Our ref: KT/2024/131869/01
20035862
Your ref: TR020005
Date: 18 December 2024

Gatwick Airport Northern Runway Scheme – Environment Agency response to comments from the Secretary of State for Transport

Water Environment

DRAWING TITLE
Project Wastewater Infrastructure

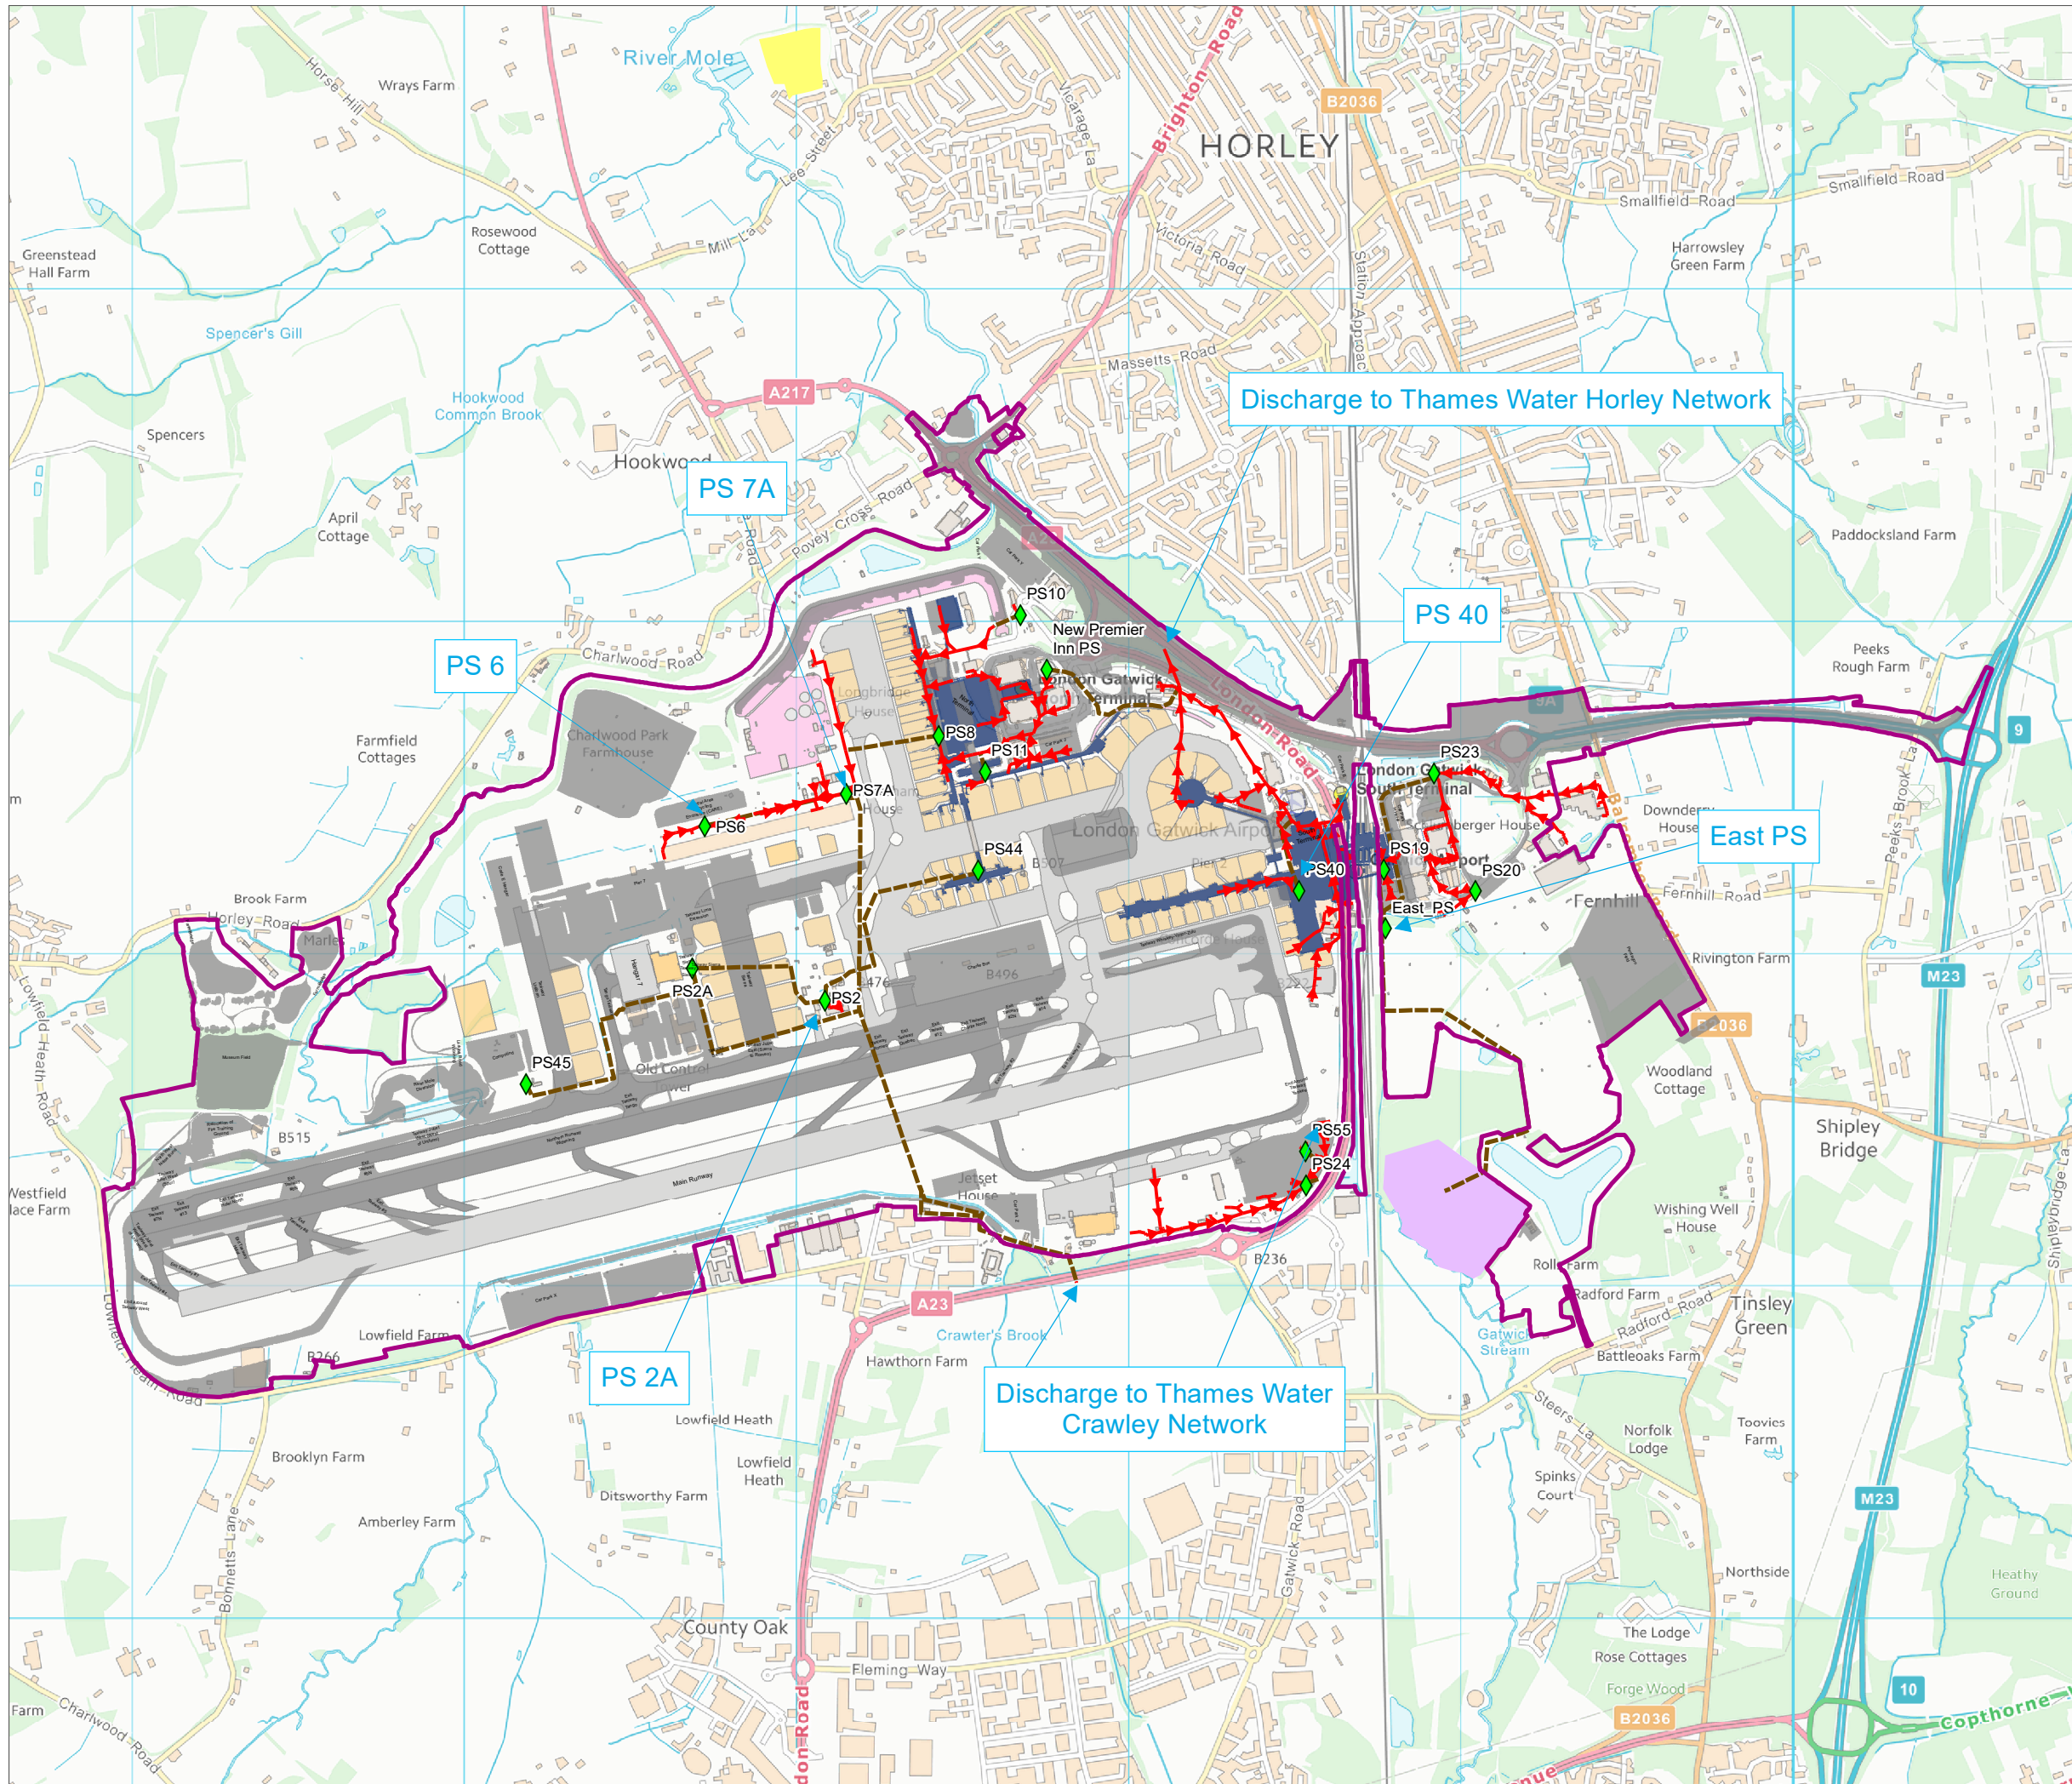
We have stated previously that in principle we would have no objection to the installation of a new wastewater treatment works.

We have not received any further details on the proposed capacity of the works as this depends on if the flows to the new works are for the uplift in capacity only or for the full volume generated from the facility. This would require disconnection from the foul sewer network.

The use of New Appointments and Variations (NAVs) to operate the new (full capacity) wastewater treatment works is a possibility but it is not possible to provide any further assurances until there are more details available on the proposed treatment proposal.

Any decisions could only be made during the determination of any application submitted by the proposer, where the outcome cannot be pre-determined. Any limits required on the permit, should one be issued, would be to protect the receiving environment and there is no way to know whether these limits are achievable with current technologies or what the requirements would be until full details of the proposed works are available.
